27th August 2014

Report No. CHAINVALLEY04/01

SUBJECT: Independent Peer Review of Subsidence and Impact Assessment Undertaken by Ditton Geotechnical Services Pty Ltd: Chain Valley to Mannering Colliery Connection Roadways

FIGURE 2. Approximate Scale Cross-Section from Surface to Fassifern Seam in Area of Proposed Connection Headings

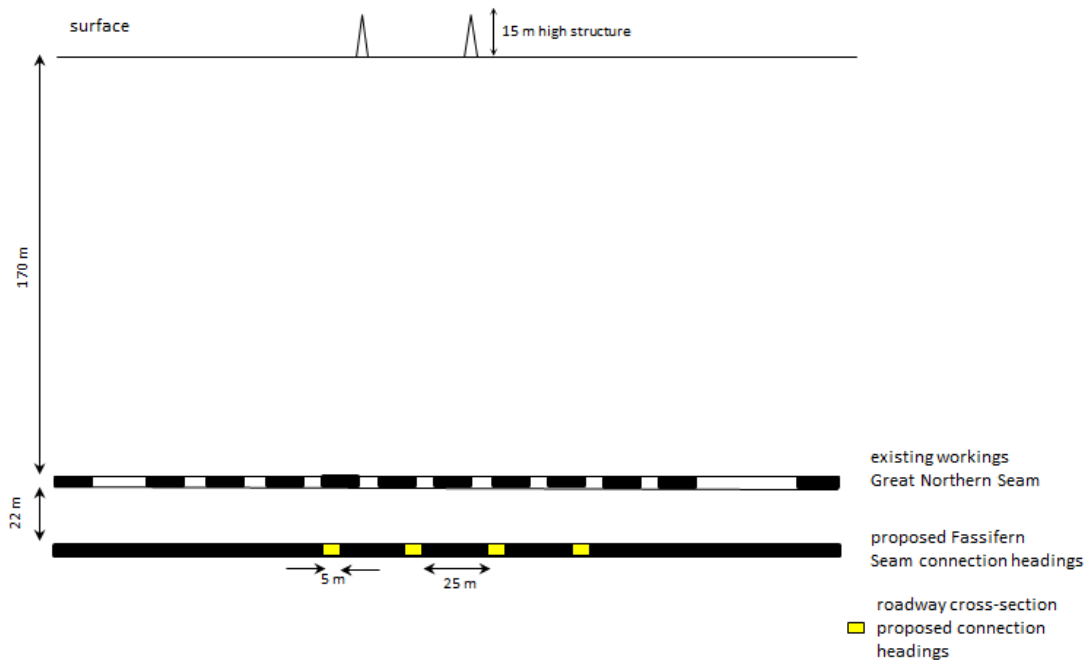
Figure 2 contains a general cross-section (to an approximate scale) from the Fassifern Seam up to surface so that both the vertical proximity of mine workings in different coal seams and the relative scale in terms of the coal removal to be required as part of the proposed connection headings can be visualised.

FIGURE 4. Predicted Subsidence Isopachs Due to the Formation of the Connection Headings in the Fassifern Seam and Surface Features (Reproduced Figure 18b from DGS 2014)

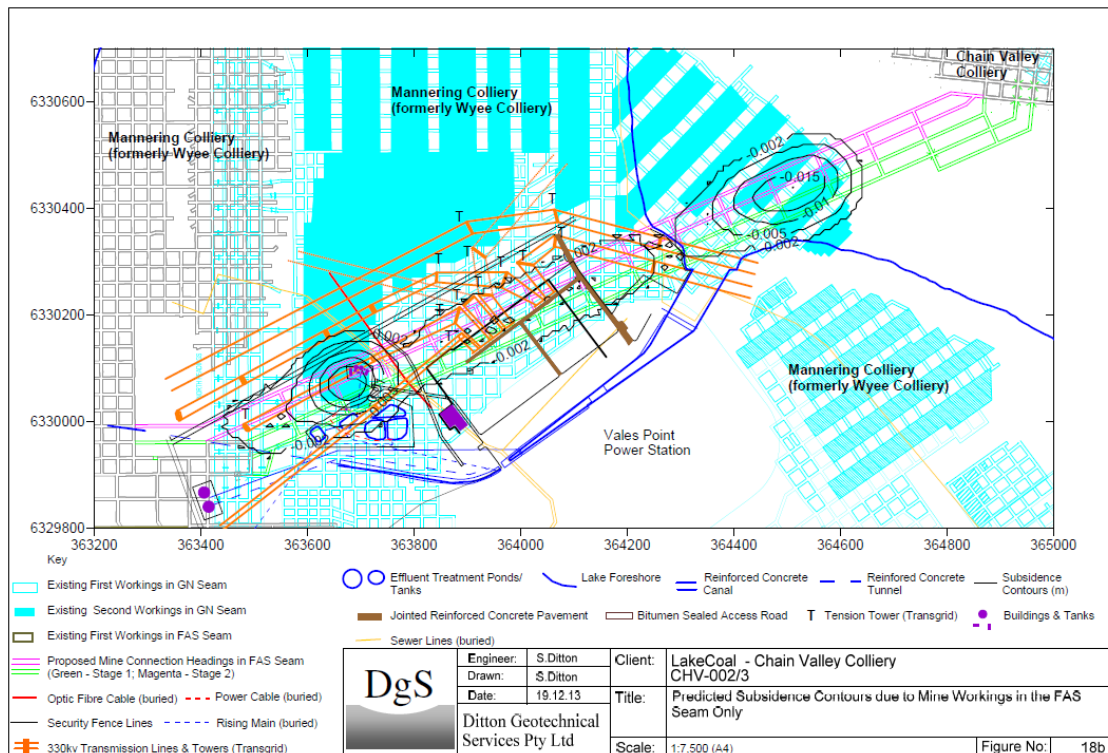
Figure 4 shows isopachs of the increase in surface subsidence as a direct result of forming the proposed connection headings along with the various surface features that are of relevance. This figure along with those detailing tilts, curvatures and strain provide a credible basis for assessing the likely impact on the various defined surface features due to the formation of the Fassifern Seam connection headings.

The areas of pre-existing second workings in the Great Northern Seam are logically where the highest level of additional surface subsidence has been predicted due to the formation of the connection headings. Up to 25 mm of additional vertical lowering is predicted in these areas, albeit that the lake foreshore is limited to in the order of 2 mm of additional lowering due to the Great Northern Seam workings having been restricted to first workings directly under the foreshore.

The TransGrid infrastructure of the Vales Point sub-station and nearby transmission towers (some of which are known to be tension towers) is situated above first workings in the Great Northern Seam such that the predicted increase in vertical subsidence as a result of forming up the proposed connection headings in the Fassifern Seam is 6 mm and less, again noting the conservative assumptions used by DGS when calculating these values. The associated maximum values of curvature, tilt and strain are $< 0.03 \text{ km}^{-1}$, $< 0.2 \text{ mm/m}$ and $< 0.3 \text{ mm/m}$ respectively. **Figure 4** also indicates that the majority of the TransGrid tension towers are located outside the 2 mm additional surface lowering isopachs so will be influenced by $< 2 \text{ mm}$ of vertical lowering due to the proposed mining.

Overall, it is judged that the vertical subsidence predictions provided by **DGS 2014** are at the absolute low end of what can be considered as “meaningful predictions” in that any lower values would almost certainly lead to a conclusion of “zero” subsidence. It is considered that the various predictions as they relate to TransGrid infrastructure can be classified as “imperceptible” levels of increased surface subsidence as it is likely that they will result in no obvious visible changes to surface conditions and may not even be detectable using survey methods (dependent upon local near-surface strata conditions).
